RE: Bengalla Coal Mine Modification 4 – Statement of Environmental Effects

I refer to the application from Hansen Bailey on behalf of the Bengalla Mining Company ("the Proponent") for Modification 4 of the Bengalla Continuation Project approval (SSD-5170). I am pleased to provide the following submission on behalf of Muswellbrook Shire Council ("Council") with respect to the Proponent's Statement of Environmental Effects dated December 2017.

Approved Development Layout

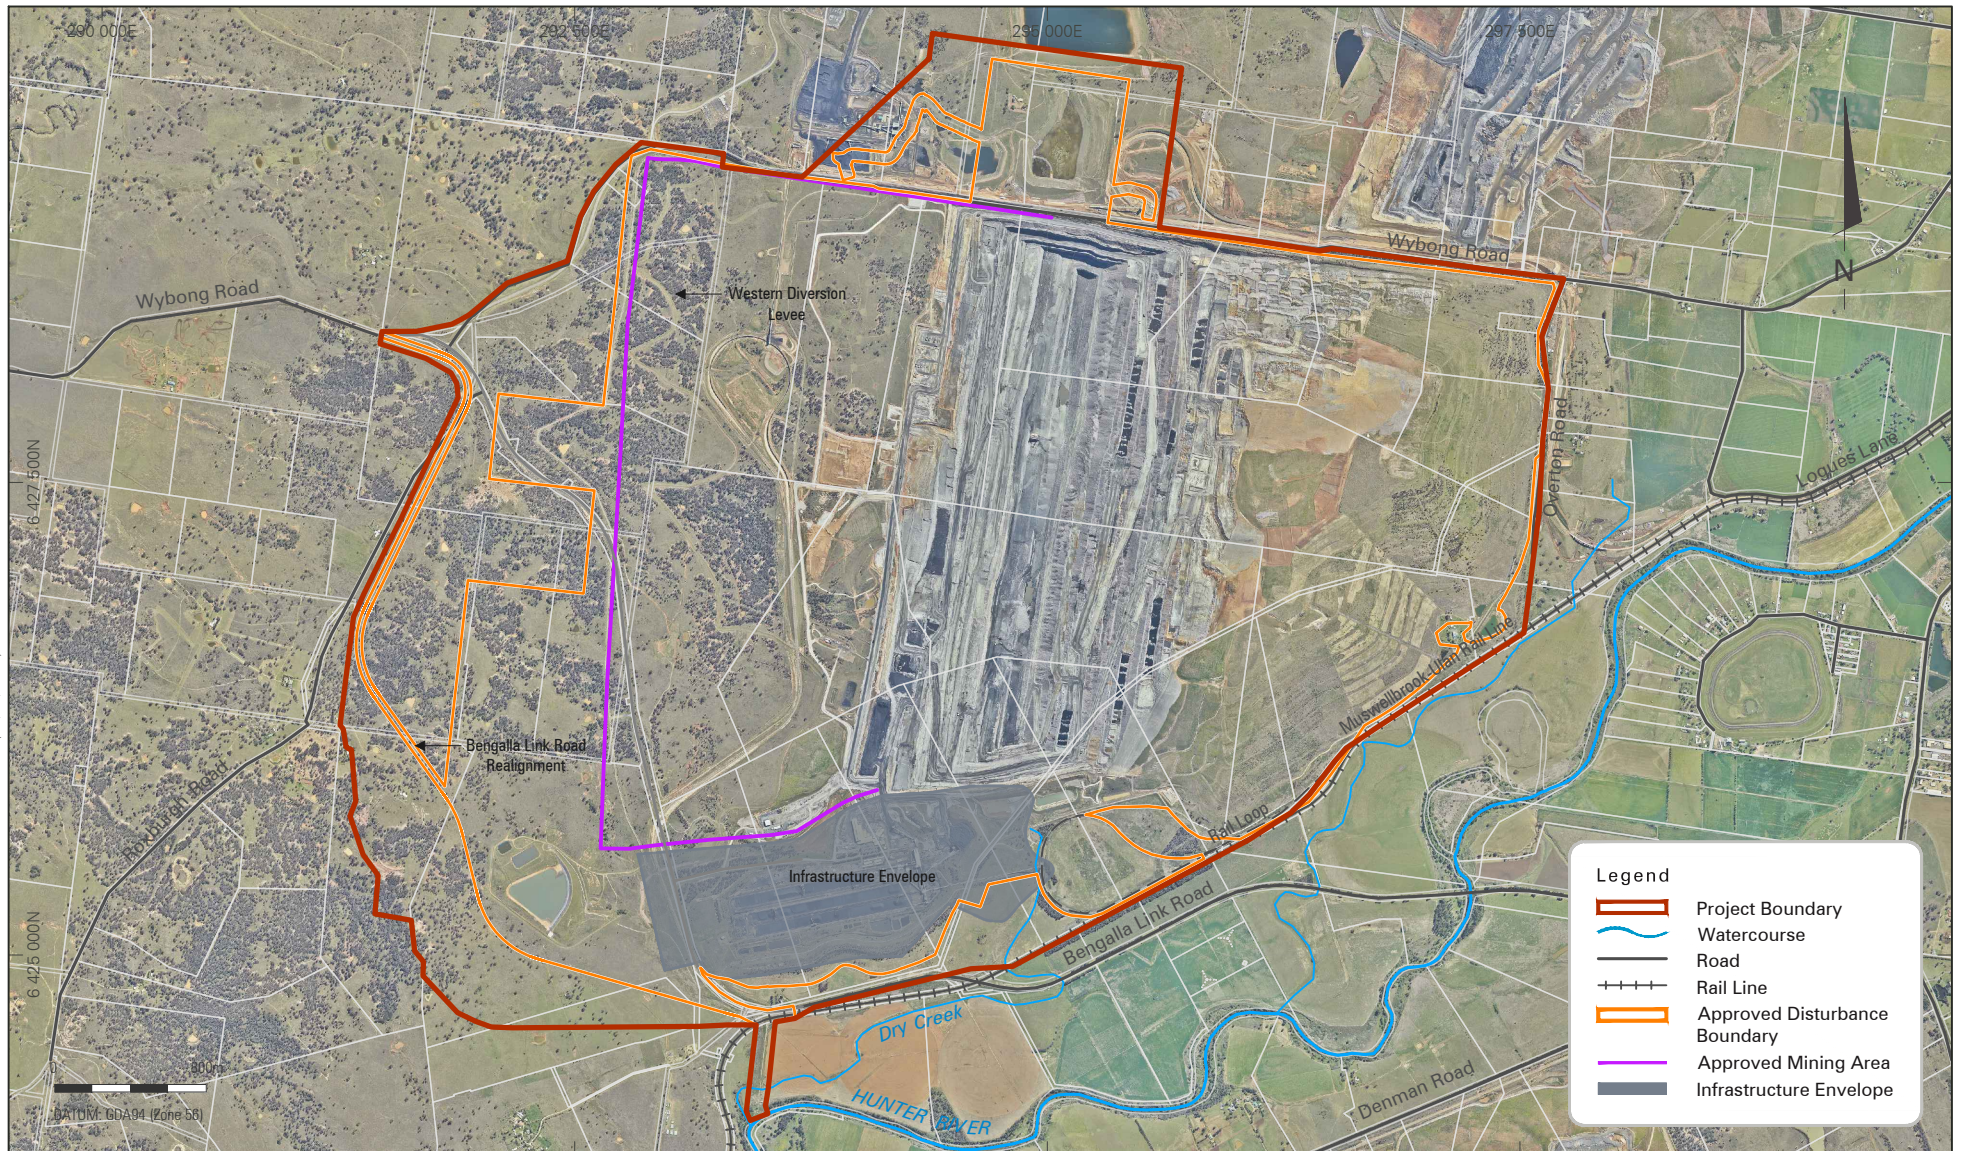
The modification proposes to build a new dam, called the Dry Creek East dam immediately north of the rail loop. The purpose of this dam is to initially hold mine water, and in time capture runoff from the rehabilitated areas. It is to remain post closure. Some of this dam is located on the Hunter River alluvium. Due to the location of the dam on the alluvium and the minimal studies provide in the Application, Council is concerned it may leak and pollute the alluvium with saline mine water.

- i. the Dry Creek East dam should not be located on any part of the alluvium;

- ii. Further studies are to be undertaken to determine the likelihood of the dam leaking saline water and provide recommendations on how this risk can be avoided and the alluvium not polluted with mine water;
- iii. Should the building of the dam be approved in its current location, Council be provided with monitoring results with the purpose of satisfying Council that the water quality within the alluvium is not being compromised by the dam.

The Run of Mine (ROM) pad is to be significantly enlarged from 350,000t to 1,250,000t, an increase of 900,000t. This has the potential to generate additional coal dust in windy conditions and when being loaded into or out of the stockpile. The dust management methodology is not described in the application. The application only offers to apply techniques consistent with the Bengalla Air Quality Management Plan. As the ROM pad currently does not exist, its management will not be currently covered in this plan.

- i. The Consent to contain methodology and the minimum requirements to manage the potential for dust generation from the ROM coal pad and its use. This should include permanent irrigation systems and controllers that respond to differing weather conditions.
